**New Request for Advice – Sydney Business Park – Stage 3  
(SSD-10477) (Blacktown)**

## TAB A - TfNSW comments on SSD-10477 Sydney Business Park, Stage 3 EIS

ISSUED FOR **DEVELOPMENT APPLICATION**
NOT FOR CONSTRUCTION

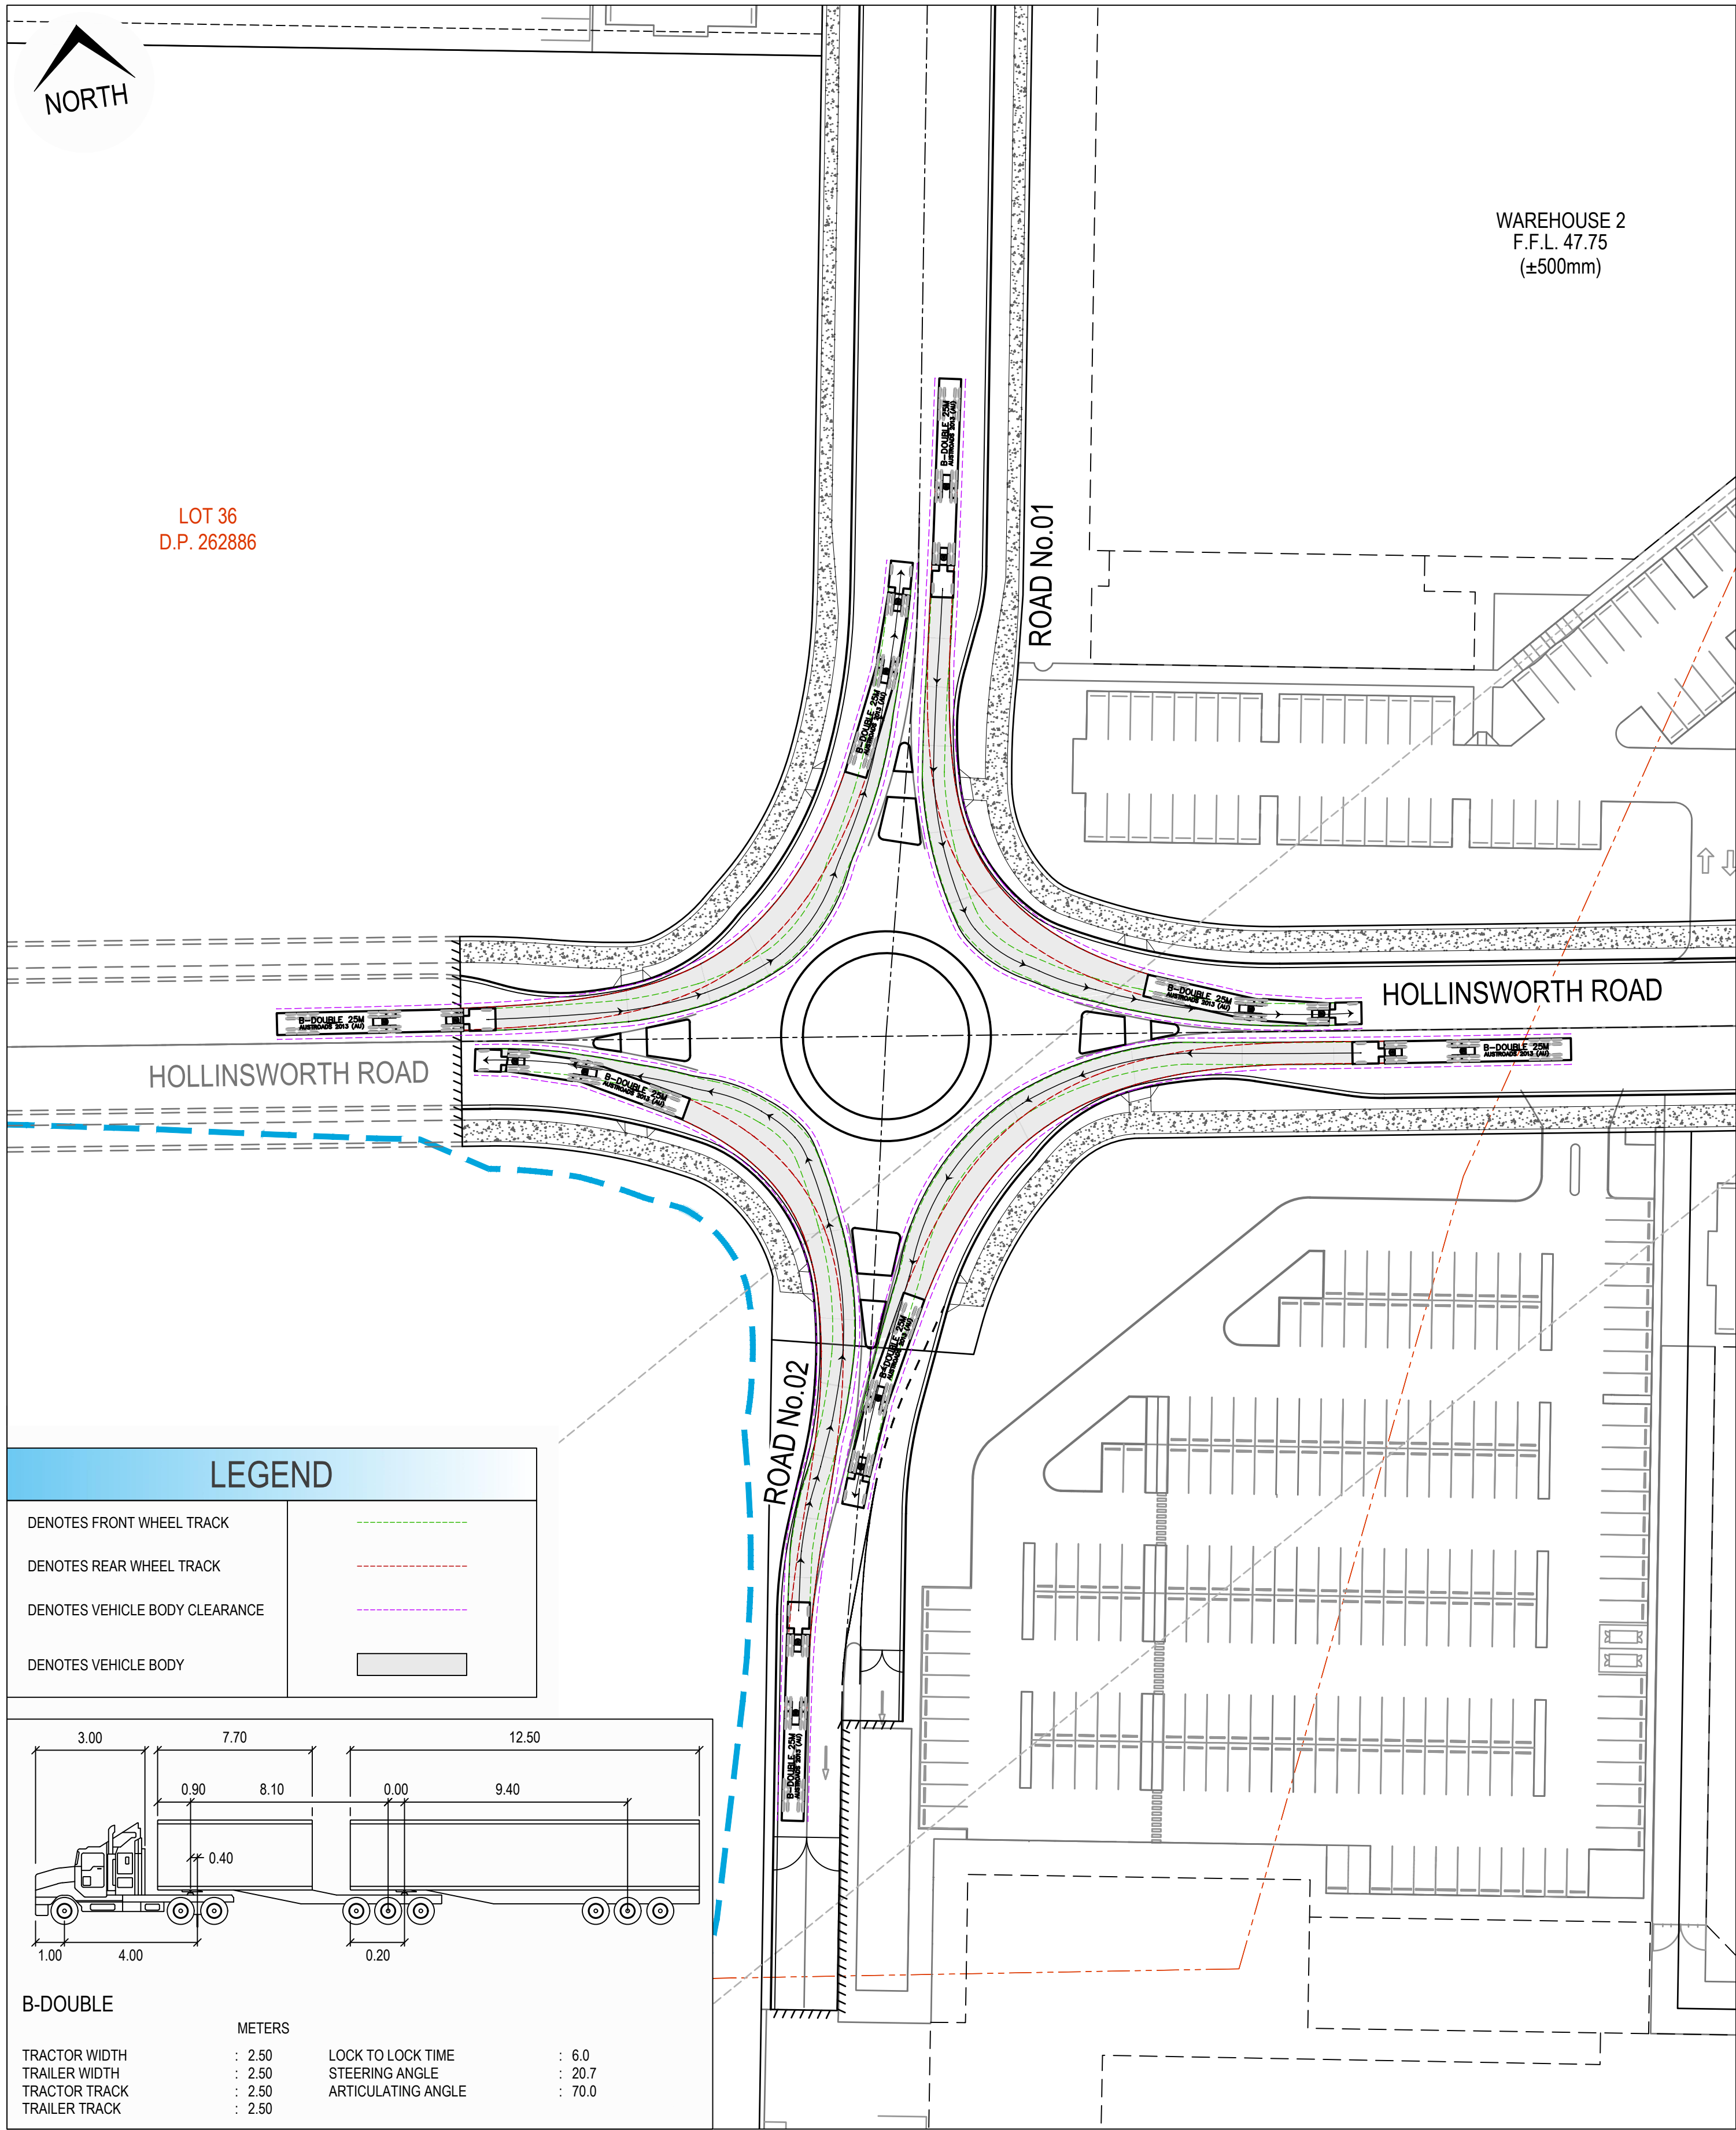
TfNSW notes that the provided swept paths for B-Doubles overlaps with the kerbs at the roundabout and at exit/entry locations of all the warehouses.

It is requested that updated swept paths of the longest vehicle (including garbage trucks, building maintenance vehicles and removalists) entering and exiting the subject site, as well as manoeuvrability through the site are to be provided and shall be in accordance with AUSTRROADS. In this regard, a plan should be submitted to Council for approval, which shows that the proposed development complies with this requirement and shows how vehicles can manoeuvre safely whilst ingressing/egressing the site as well as manoeuvrability within the site.
